**Proposed Highway Improvement works at A41/High Street junction,  
Westcott, Buckinghamshire**

<b>Project:</b>	SHF.110.004.TR.001
<b>For:</b>	Rockspring Property IM
<b>Status:</b>	Final
<b>Date:</b>	April 2018
<b>Author:</b>	Sarah Strauther – Senior Transport Planner
<b>Reviewer:</b>	Barry Roberts BSc (Hons)   Eng MICE MIHT – Director of Transport
<b>Approver:</b>	Matt Travis, BSc (Hons), MSc, MCIWEM, C. WEM, CEnv, CSci – Director

**Transport Statement**

PROJECT: Westcoast Venture Park
CITY: TRD, CA
PROJECT NO: SHF-110.001-TR.D.100A

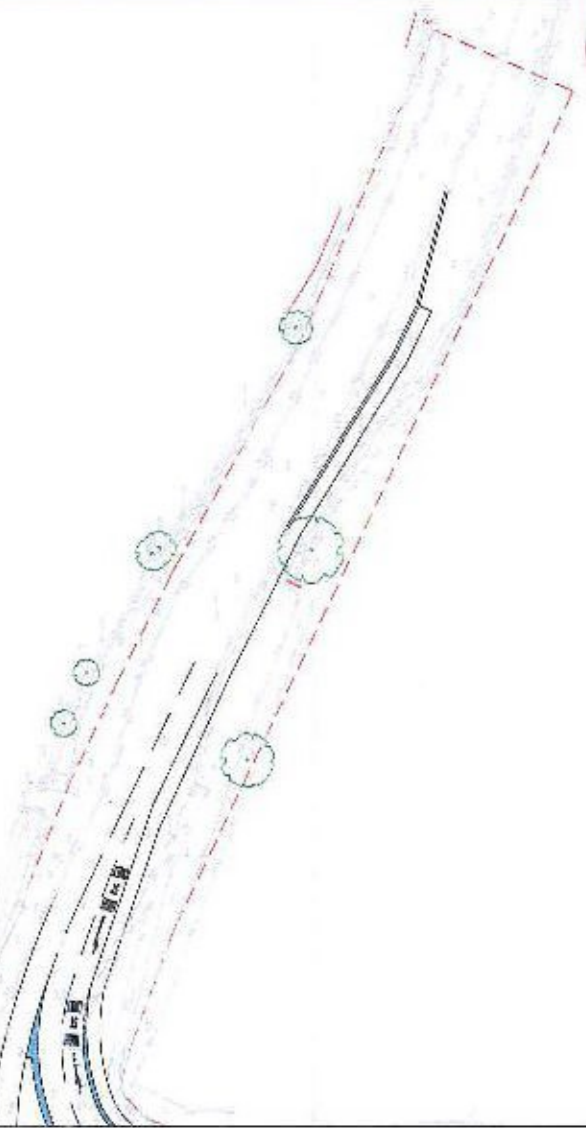
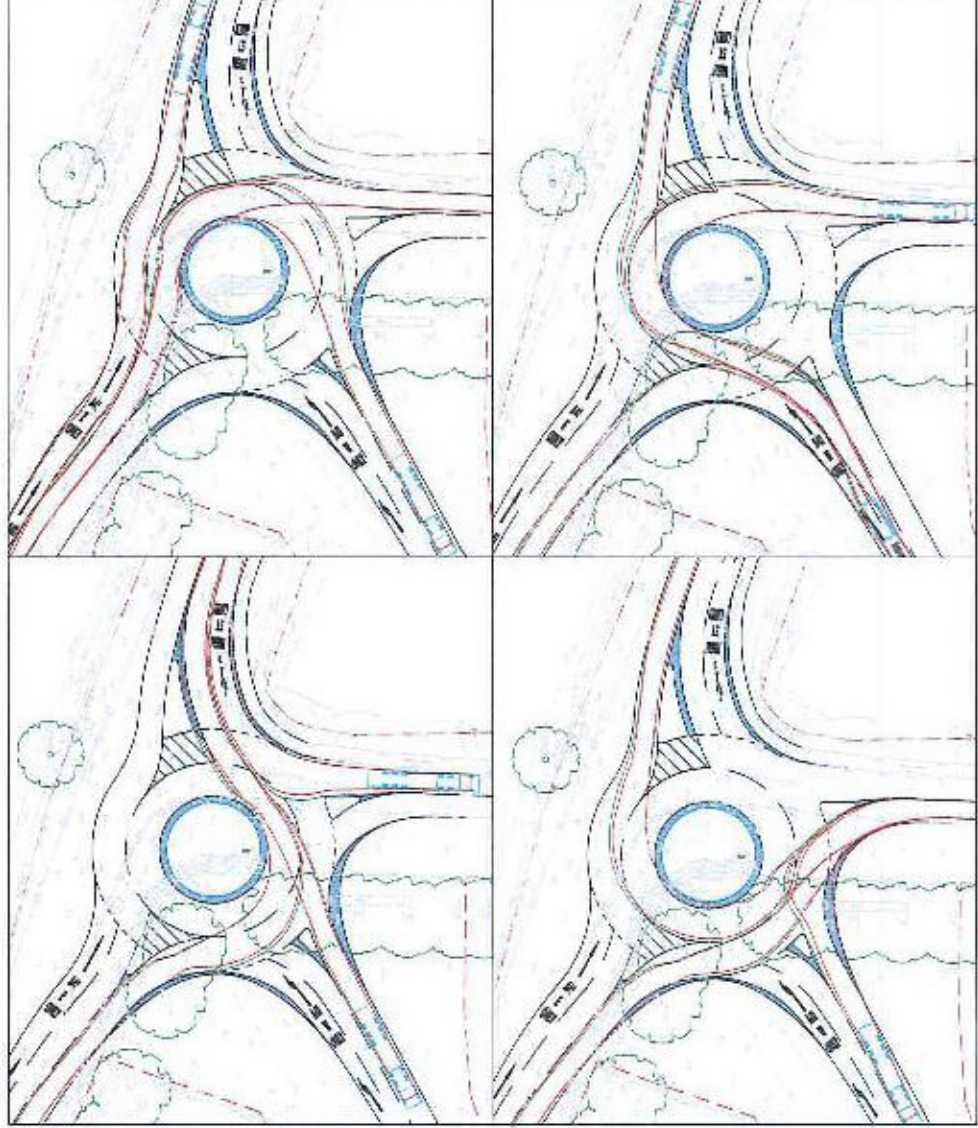
4.2.5 A preliminary roundabout design was submitted to BCC and a Stage 1 Road Safety Audit (RSA) was subsequently carried out. The Stage 1 RSA identified several concerns with the original design proposed. These included the following:

- 1) Restricted forward visibility between vehicles on High Street and A41 westbound;
- 2) Restricted forward visibility along A41;
- 3) Excessive / acute entry angle;
- 4) Difference in levels between High Street / Venture Park and A41 carriageway;
- 5) Recognition of the roundabout junction during hours of darkness;
- 6) Large vehicles overrunning adjacent lanes;
- 7) 2 lane approach designation;
- 8) Provision for cyclists, pedestrians and horse riders; and
- 9) Repositioning of bus stops.

4.2.6 The concerns identified in the Stage 1 RSA were addressed and subsequently responses were received from BCC. The concerns above have been addressed and agreed with BCC as follows:

- 1) Visibility conforms to DMRB Vol 6 section 2, Part 3 TD 16/07 Para's 8.5, 8.6 and 8.7. BCC confirm that any visibility detail is to be considered at detailed Stage 2 RSA;
- 2) The capacity modelling assessments reveal minimal queuing at the proposed roundabout and Enzygo propose that visibility along the A41 is sufficient in terms of risk of collisions, given that the junction layout is predicted to generate minimal queue lengths. The high A41 traffic flows are accurate and have been utilised in modelling the capacity of the proposed roundabout design. We are confident that the queuing data revealed by the Junctions 8 industry standard software is proportionate as accurate data and traffic flows agreed with BCC have been utilised in the assessment.

- 3) Design has been revised to account for this concern. BCC agreed;

- 4) We are aware of the potential level differences and once we have a revised topographical survey these will be addressed at the detailed design/S278. BCC agreed;

- 5) Street lighting will be provided as part of the Section 278 design works. BCC agreed;
- 6) Design amended to accommodate all manoeuvres, supported by swept path analysis. Drawing SHF.110.001.TR.D.102C included in Appendix 3. BCC Agreed subject to detailed design;

- 7) Lane discipline is provided in the form of advance lane markings and strategically positioned advance direction signs. Hatching within the roundabout is proposed to encourage drivers to follow the correct route and exit via the correct arm. BCC agreed and to be considered at detailed Stage 2 RSA;

- 8) Enzygo to undertake Walking, Cycling & Horse-Riding Assessment and Review (HD42/17) independent to the design process. BCC Agreed; and
- 9) The relocation of the bus stops further east away from the roundabout conflict points can be provided at detailed design stage. BCC Agreed to be considered at detailed Stage 2 RSA.

4.2.7 The roundabout design has been amended as discussed above following the Stage 1 RSA. At the request of BCC, the design has included for crossing points to enable safe and suitable access to bus stops, demarcation of the kerb line either side of High Street, entry widths, entry kerb radii and swept path analysis to accommodate articulated vehicles. The proposed preliminary roundabout design is shown in Drawing SHF.110.001.TR.D.101D and is included in Appendix 3.
